August 1, 2016

Re: 3404 Stanford Dr NE Addition
3404 Stanford Dr NE
Traffic Circulation Layout
Engineer's Stamp 07-28-16 (G16D151)

Based upon the information provided in your submittal received 07-29-16, the above referenced plan cannot be approved for Building Permit until the following comments are addressed:

TRAFFIC CIRCULATION  
LAYOUT APPROVED

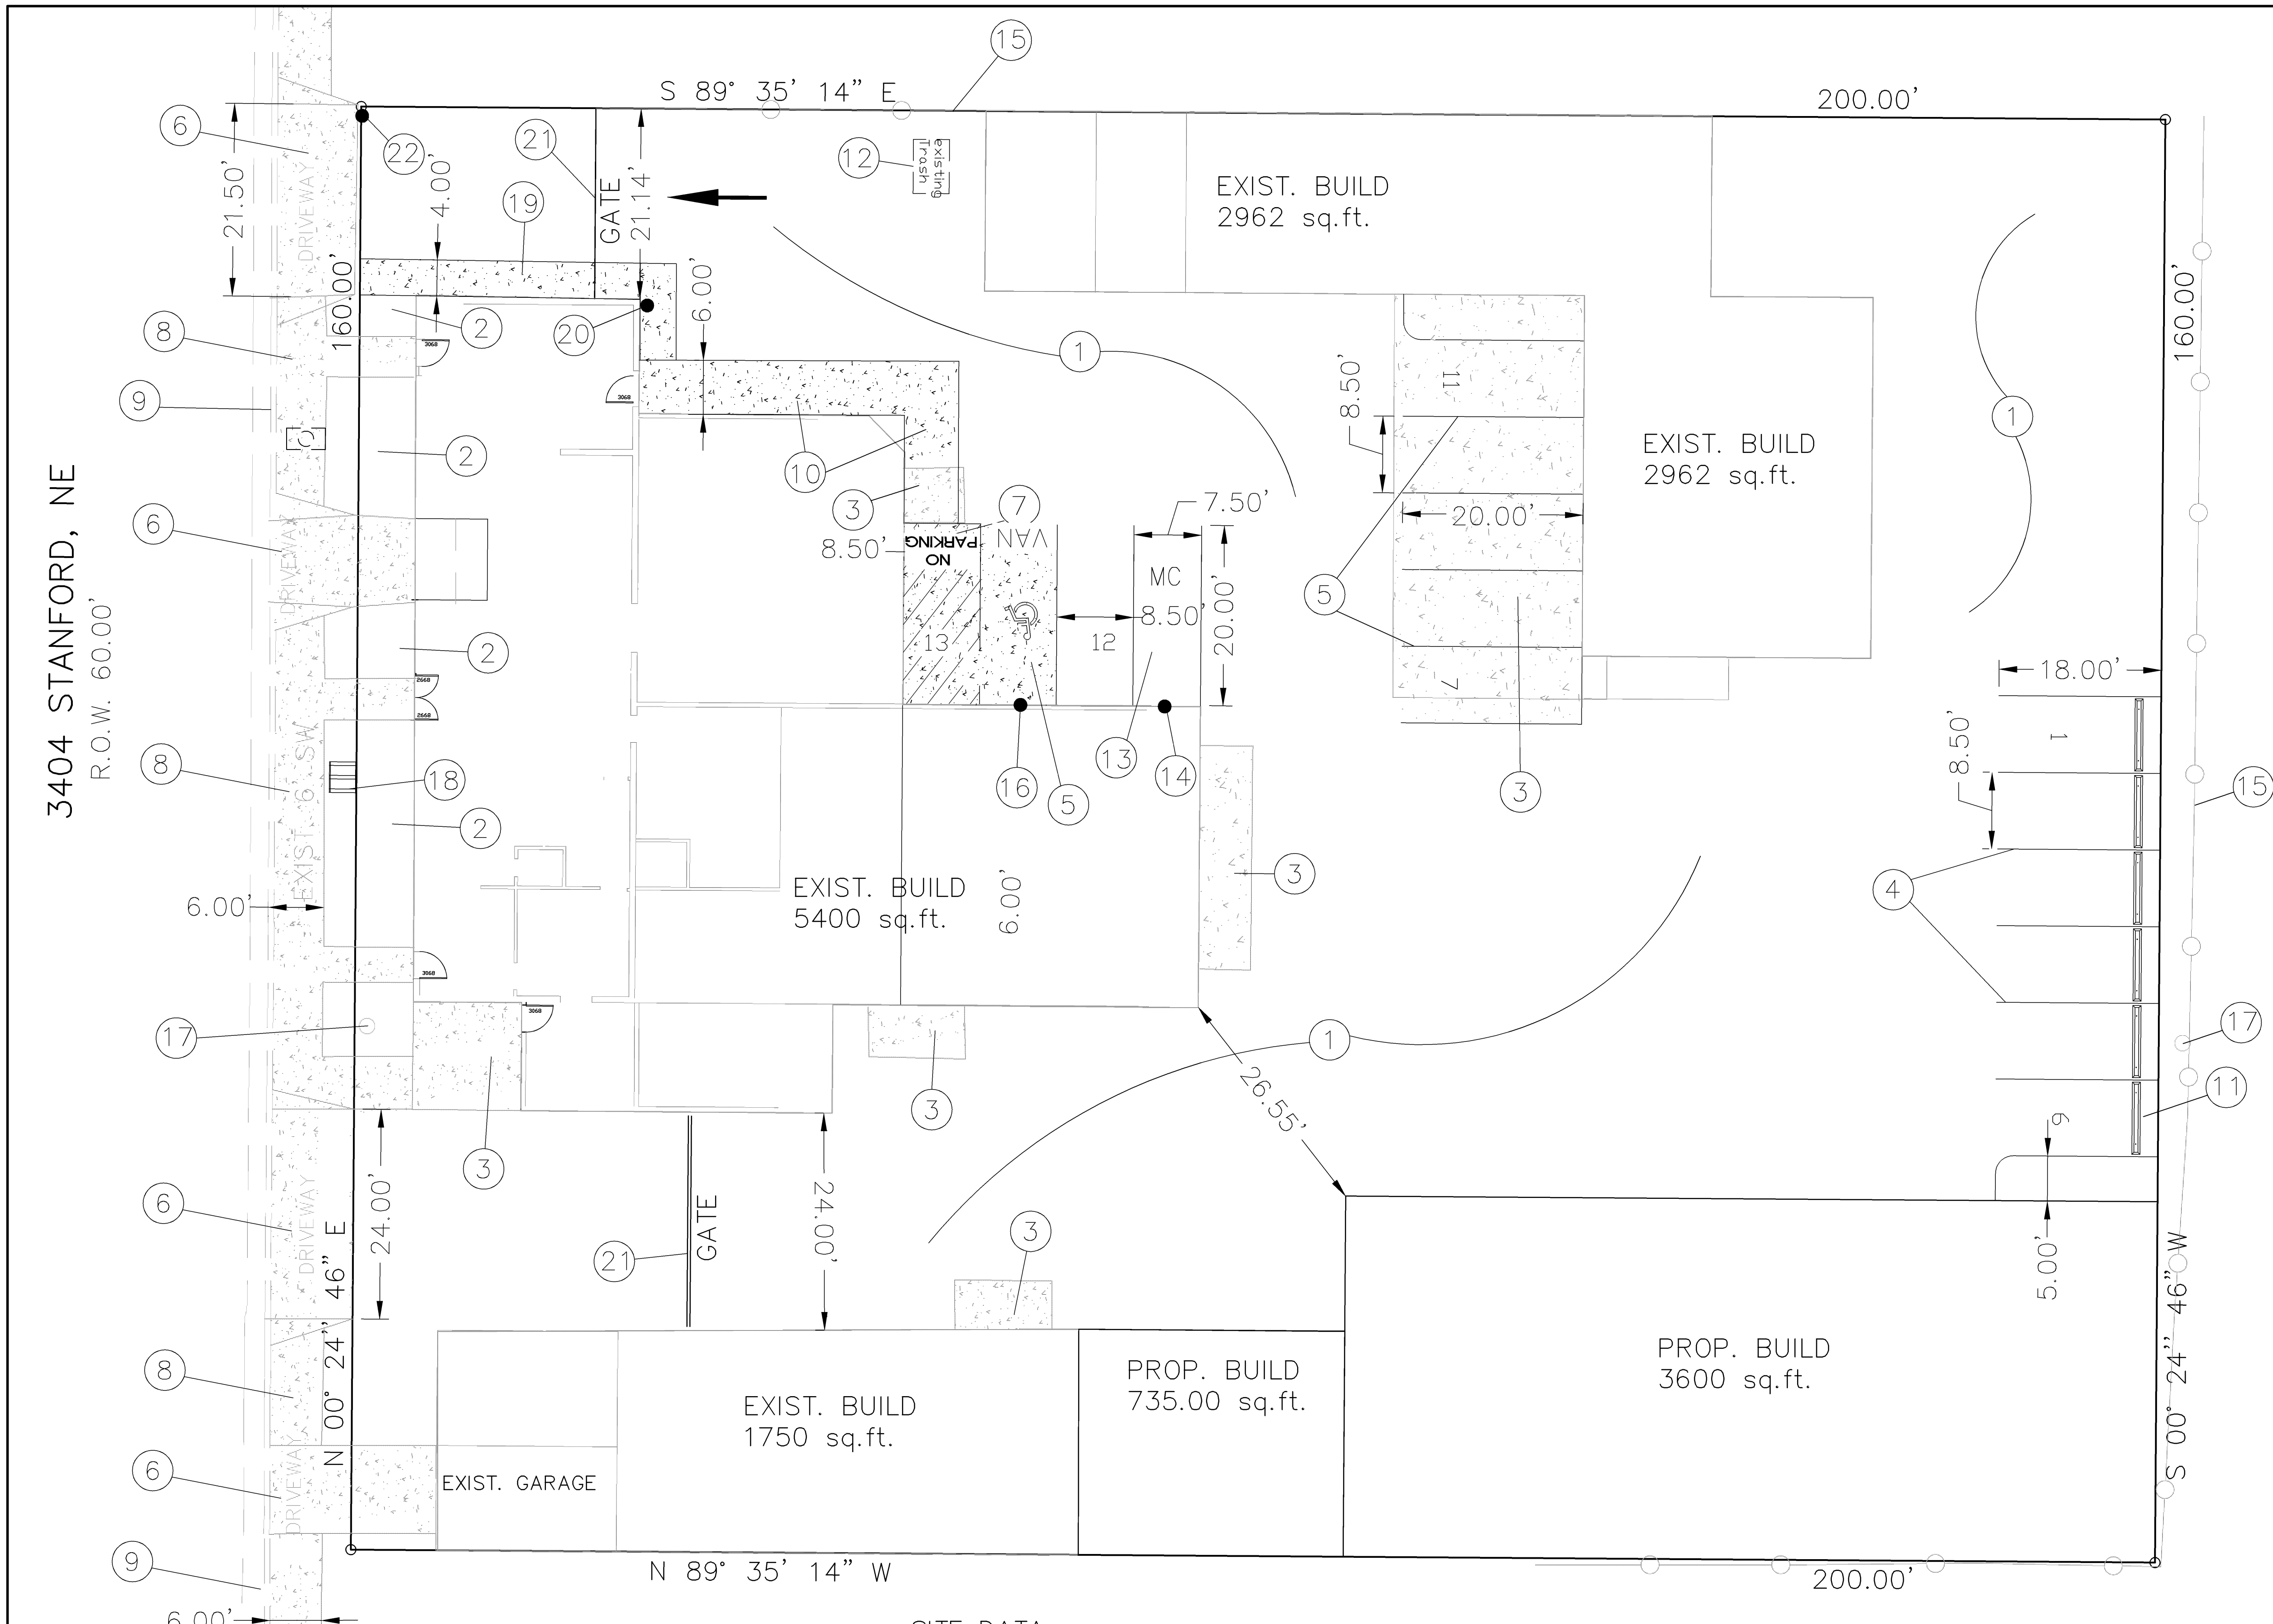
1. Show all drive aisle widths and radii.
2. List radii for all curves shown; for passenger vehicles, the minimum end island radius is 15 ft. Landscape island radius for delivery trucks, fire trucks, etc. is 25 ft. or larger.

3. Per DPM, a 6 ft. wide ADA accessible pedestrian pathway is required from the public sidewalk and handicapped parking to the building entrances. Please clearly show this pathway and provide details.

4. Per DPM, a 6 ft. wide ADA accessible pedestrian pathway is required from the HC parking stall access aisles to the building entrances. Please clearly show this pathway and provide details.

5. All sidewalks along streets should be placed at the property line.
6. Service vehicle and/or refuse vehicle maneuvering must be contained on-site; provide a copy of refuse approval.

7. Please specify the City Standard Drawing Number when applicable to all curb cuts and ramps.
8. Work within the public right of way requires a work order with DRC approved plans. Please add a note on the plan stating "All improvements located in the Right of Way must be included on the work order."

9. See Chapter 23, Section 6 of the City of Albuquerque *Development Process Manual*, for appropriate drive pad widths.
10. All broken or cracked sidewalk must be replaced with sidewalk and curb & gutter. A build note must be provided referring to the appropriate City Standard drawing.
